Briefing Note

Our ref 64194/06/MS/OW
Date 4 June 2025
To Planning Inspectorate
From Oxford Aviation Services Limited

Subject **Deadline D1 – Further Written Statement**

- 1.1 This Statement has been prepared on behalf of Oxford Aviation Services Limited (“OASL”), the operators of London Oxford Airport (“the Airport”), in response to the Rule 8 letter received concerning the application by Photovolt Development Partners (“PVDP”) for an Order Granting Development Consent for the Botley West Solar Farm project.

Title  
 Landscape, Ecology and Amenities Plan

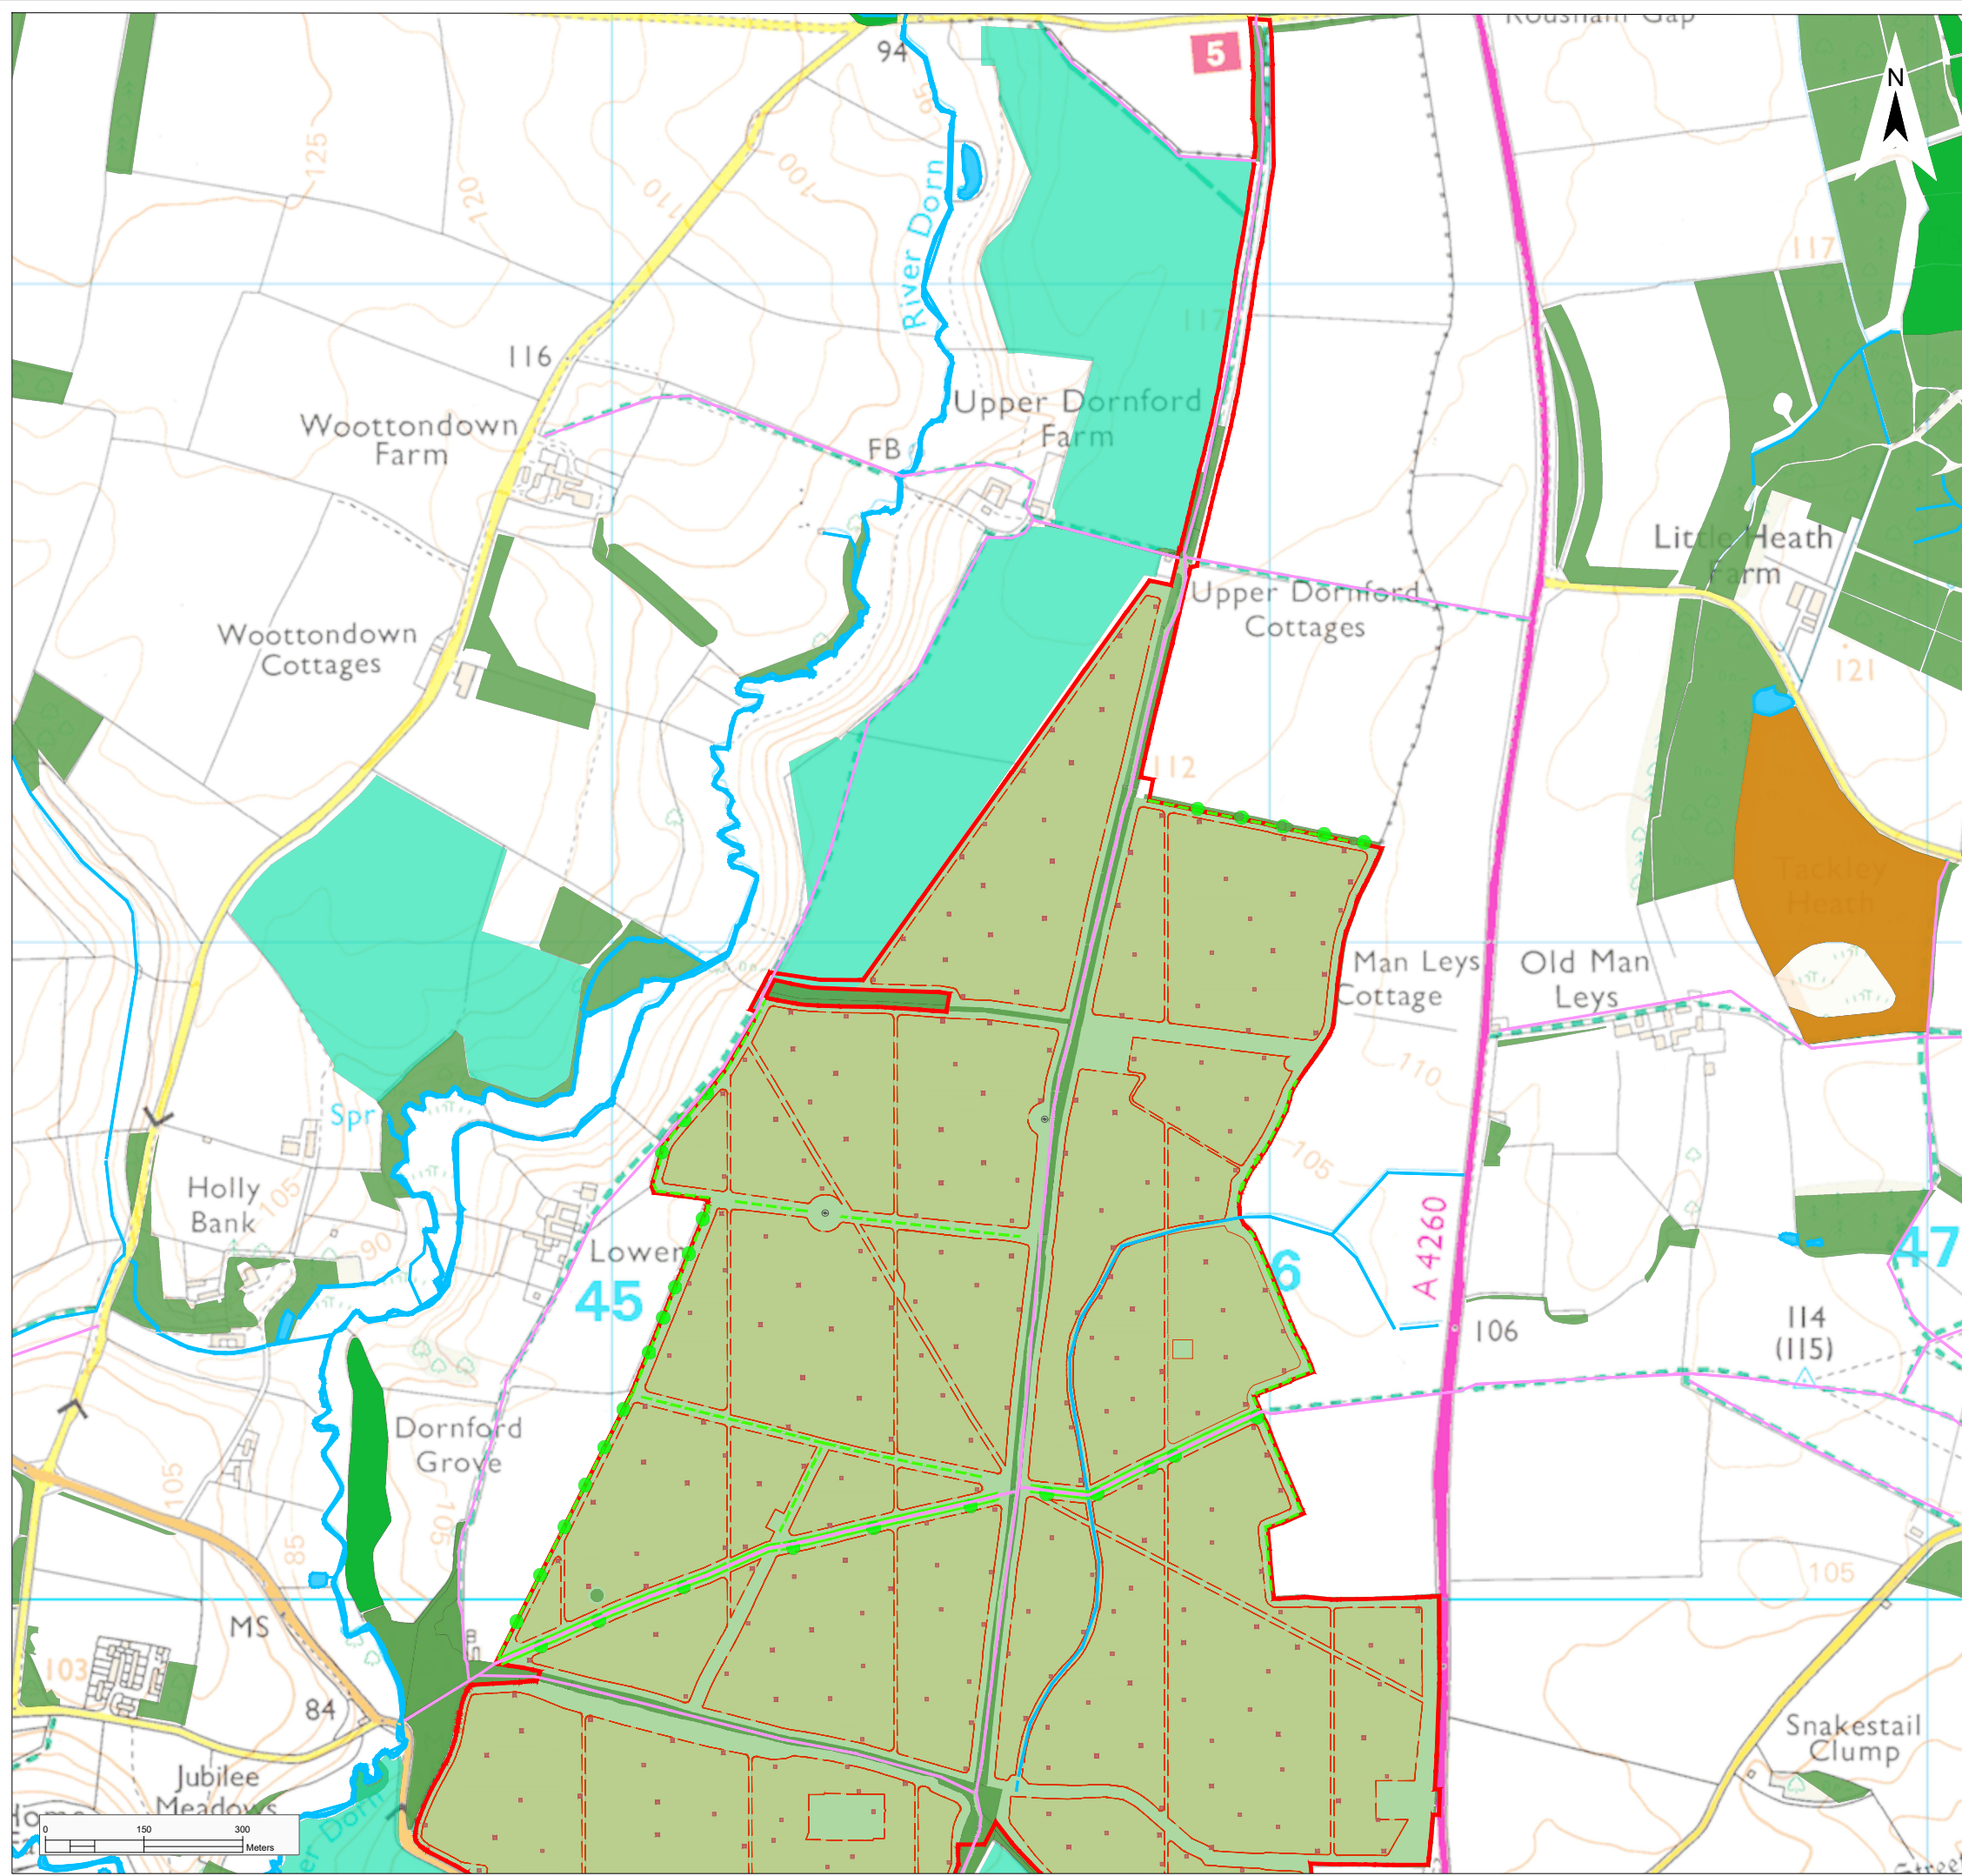
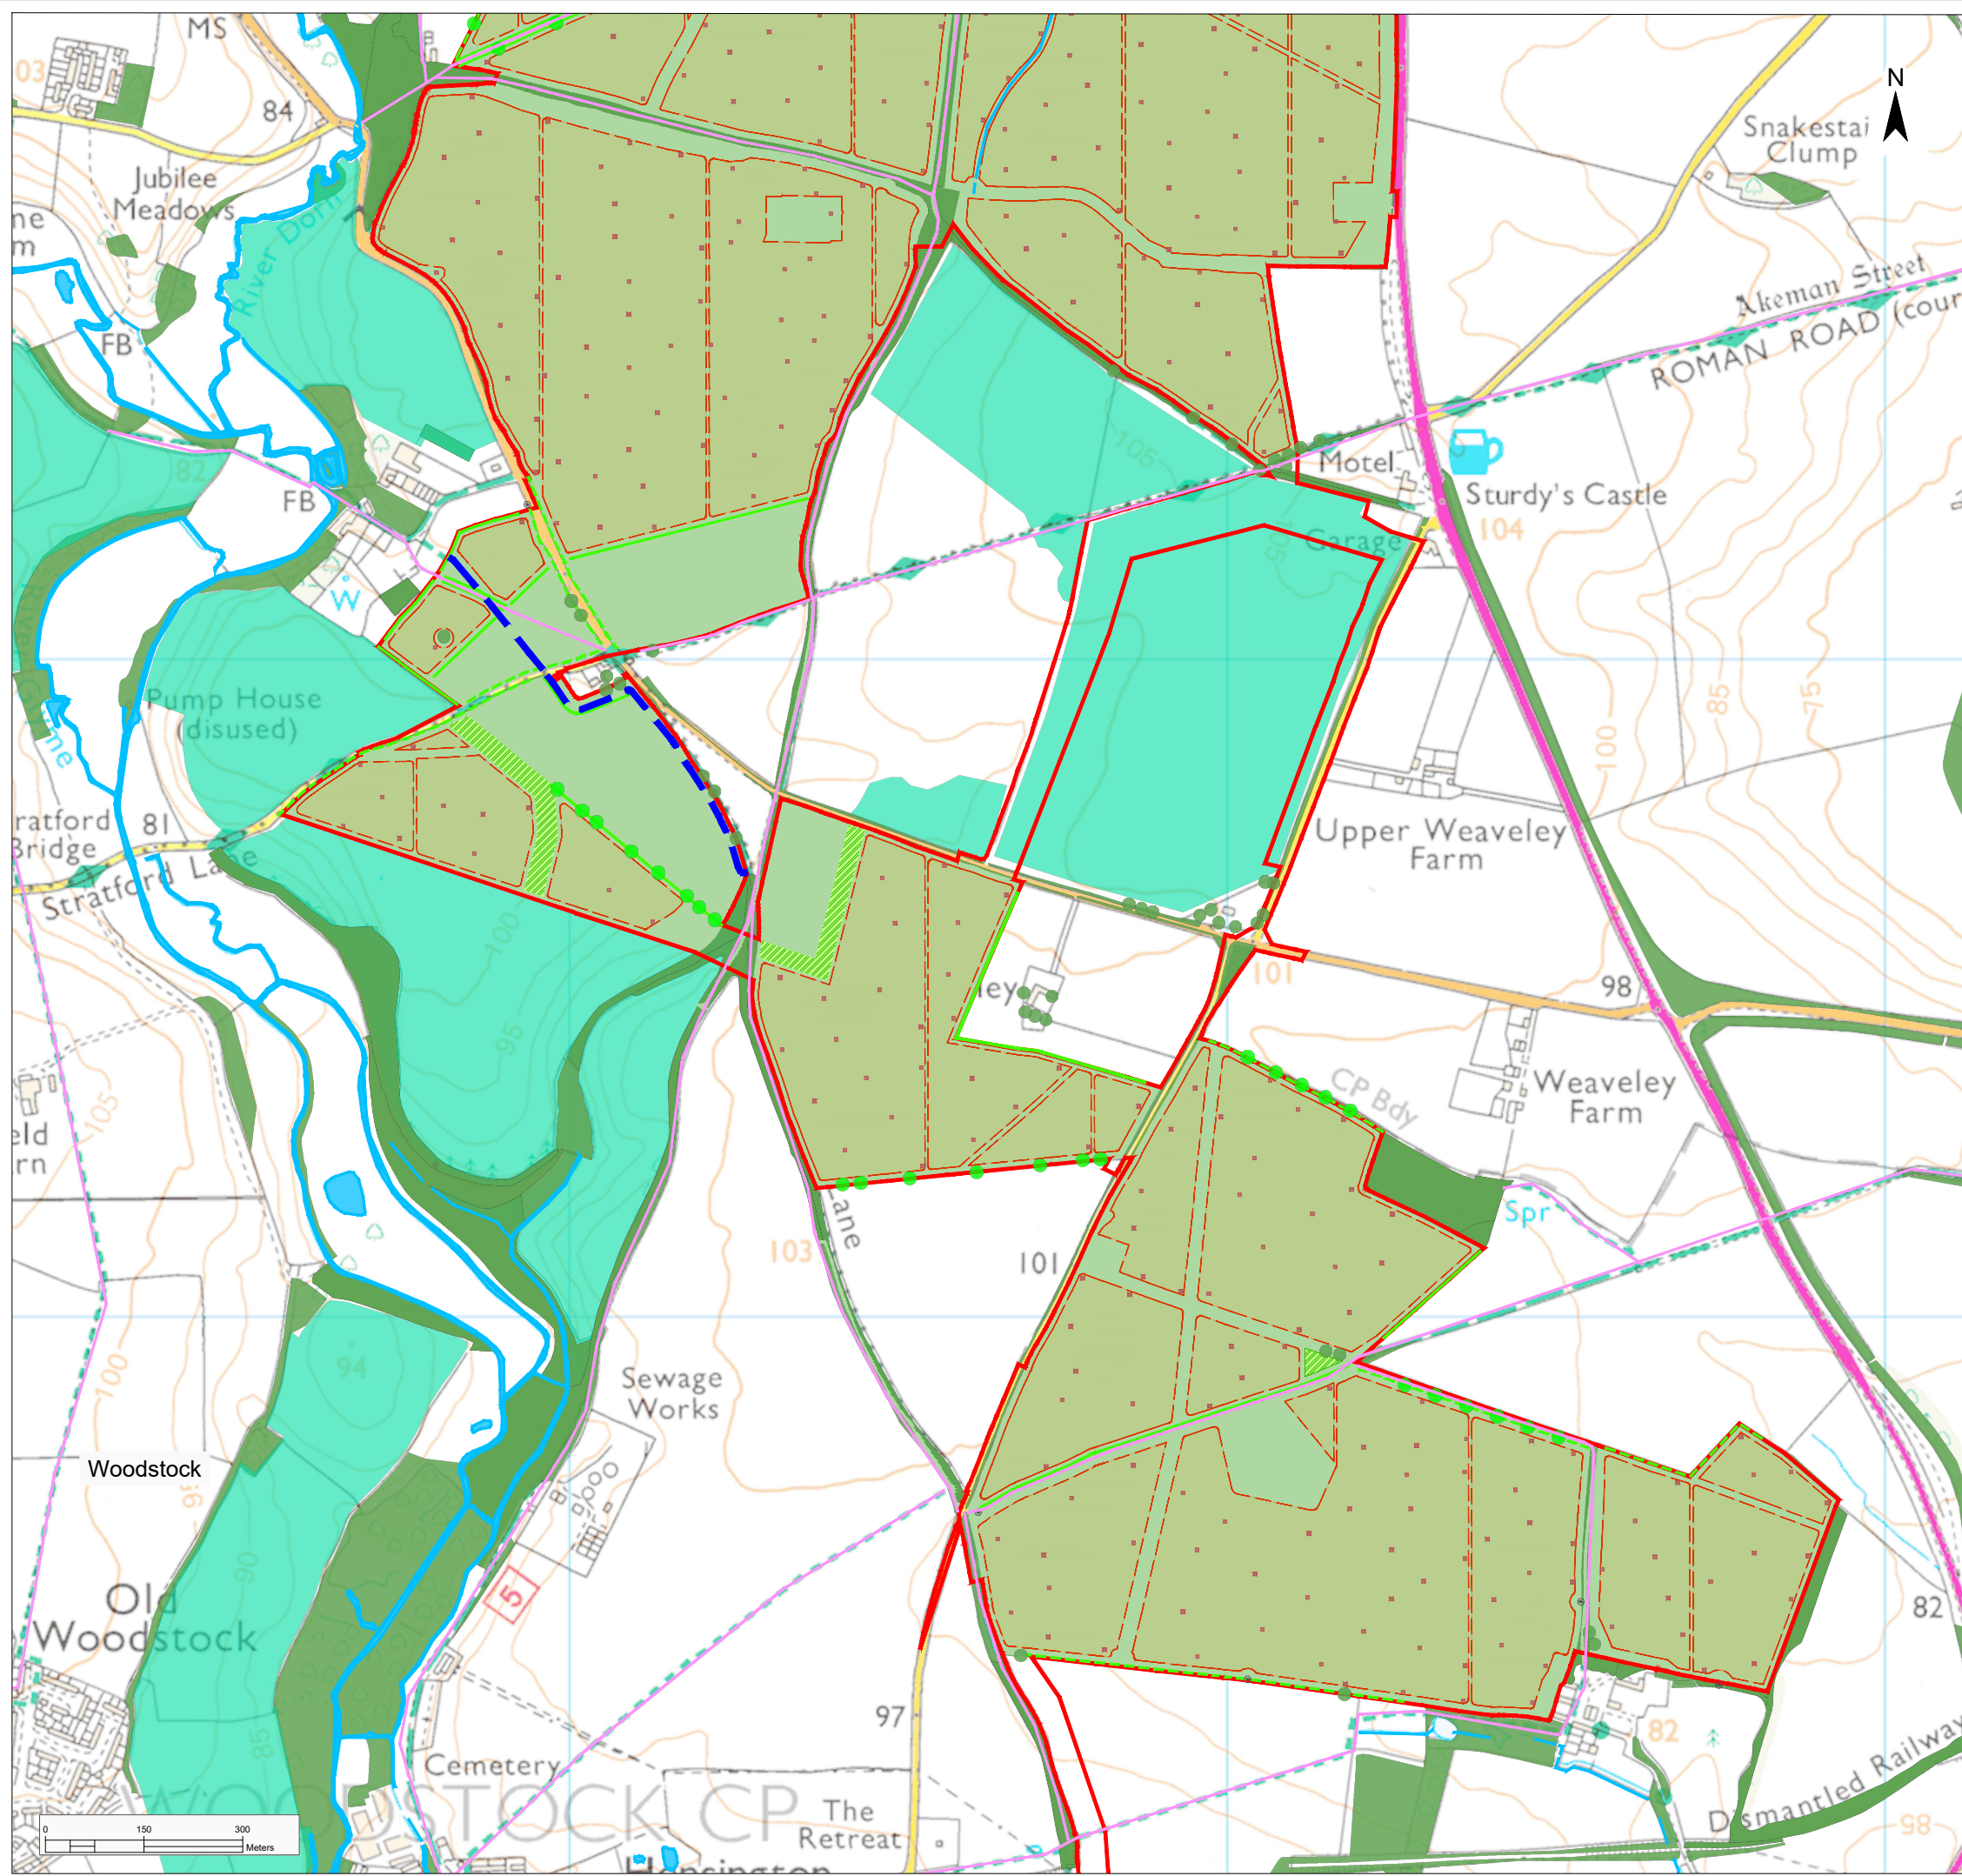
- 2.9 PVDP acknowledged that the submission documents had not considered the impact(s) of changing ecological activity around the Airport as a result of the development. It has agreed to review the proposals with a view to reducing zones of Green Infrastructure in areas around the Airport that might attract birds. They also agreed to consider other mitigations that could be introduced to assist the Airport in managing any increase in animal activity at the Airport as a result of the development.
- 2.10 PVDP agreed to present revised proposals to the Airport for review and agreement prior to submitting a proposed Change Order to the Inspectors.
